## DEVELOPMENT REVIEW BOARD

### Planning Dept. - Major Case Comments

*Project Number: PR-2018-002184*

*Project Name: Guardian storage*

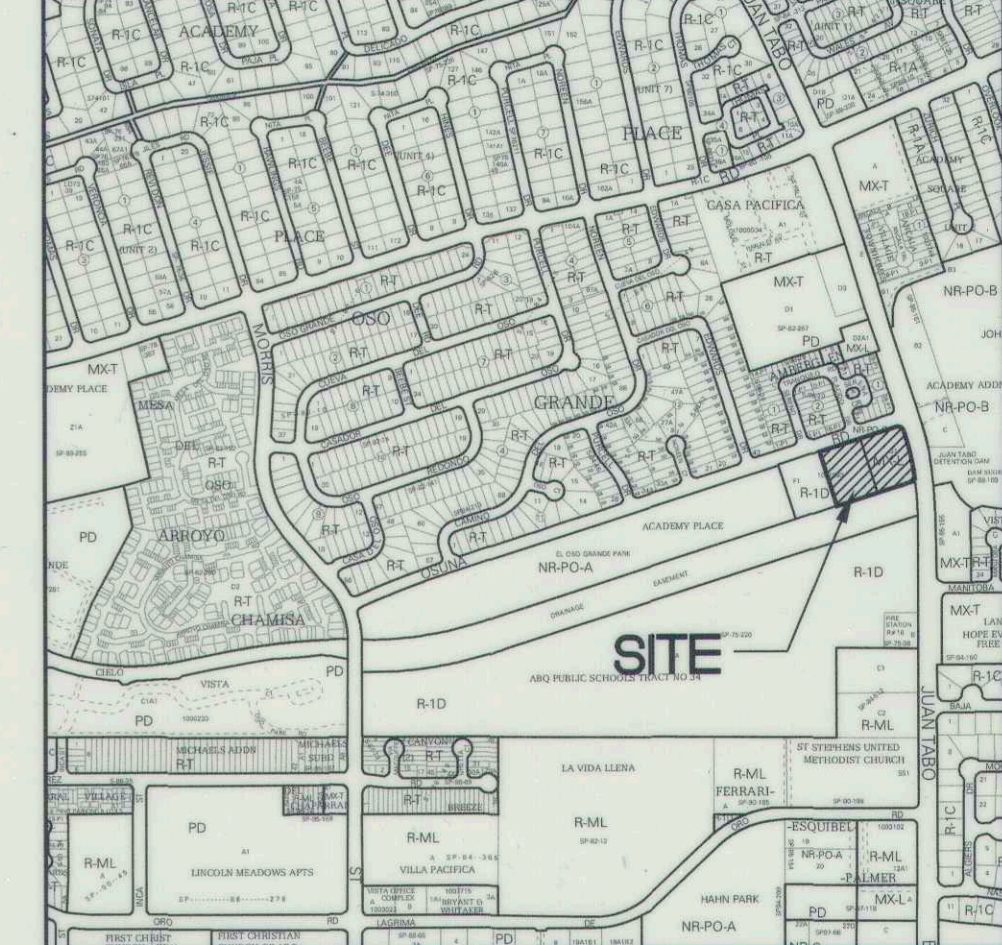
3. Confirm the number of parking spaces
4. No loading spaces are proposed, and 3 loading spaces are required.
5. Make sure that façade design in 14-16- 5-11 is being met.

6. Clarify how fencing requirements in 14-16-4-3(D)(28) are met, the fencing appears to stop before the property ends and does not appear to be opaque.

7. See 5-3-(D)(3)(b) network of walkways for required walkways- the walkways provided are too narrow
8. Please provide sign dimensions.
9. Will the buildings be internally lit at night? See section 14-16-5-8 for lighting requirements.

OSUNA ROAD ELEVATION ①
1/8" = 1'-0"

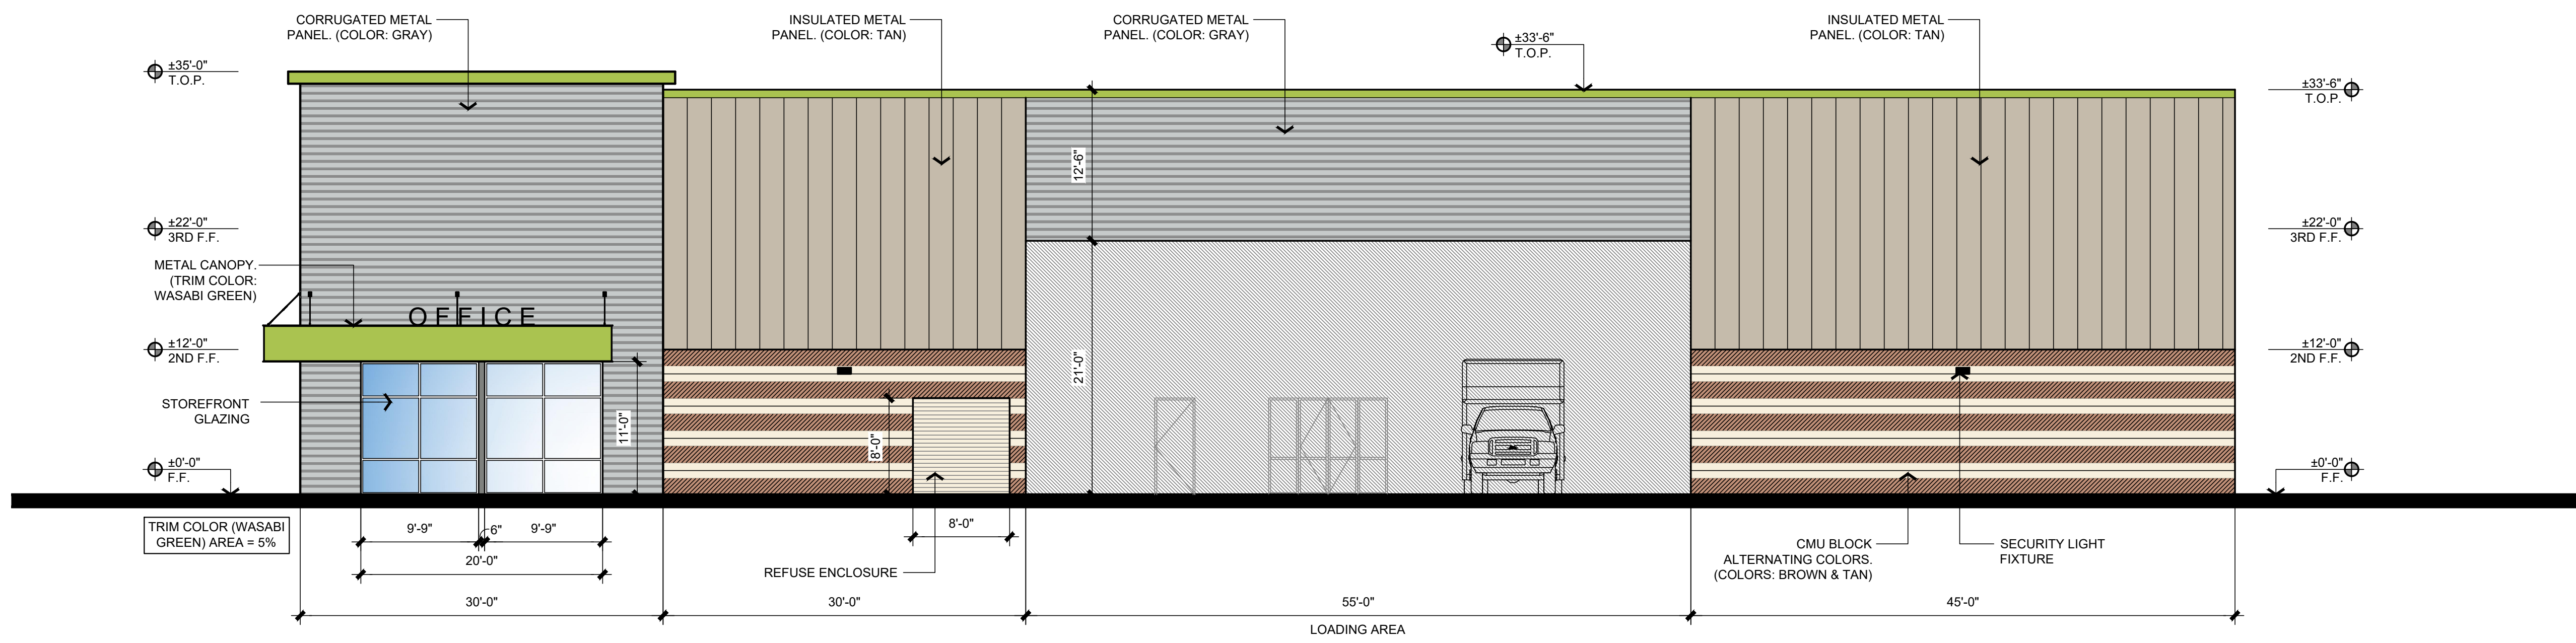
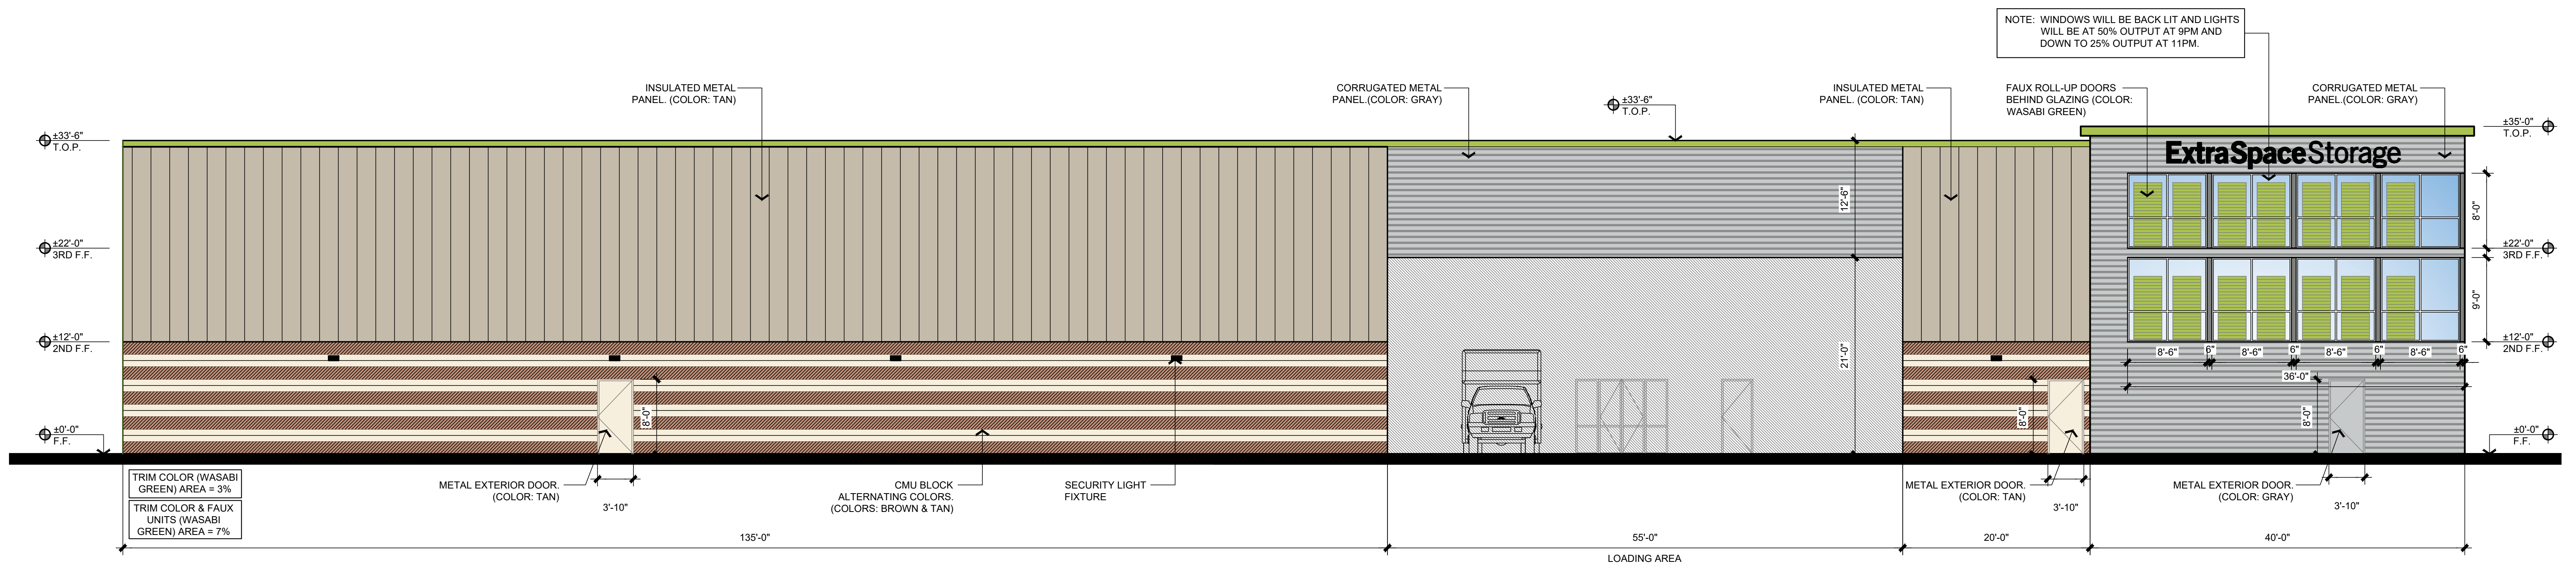
10. The building appears to have internal access for trucks to enter and unload- please confirm .
11. Please confirm the spandrel windows are opaque and not see through. Will these windows have lighting?

12. Will CMU block be split face?
13. Do building colors meet 5-2(H)(1)(a) for reflectivity. Please provide information for the colors used in the building.

14. Please clarify the shade of green, Pursuant to 5-2(H)(1)(b) colors must blend into the surrounding environment, yellow ochres, browns, dull reds and grey greens- please confirm that is a grey green.
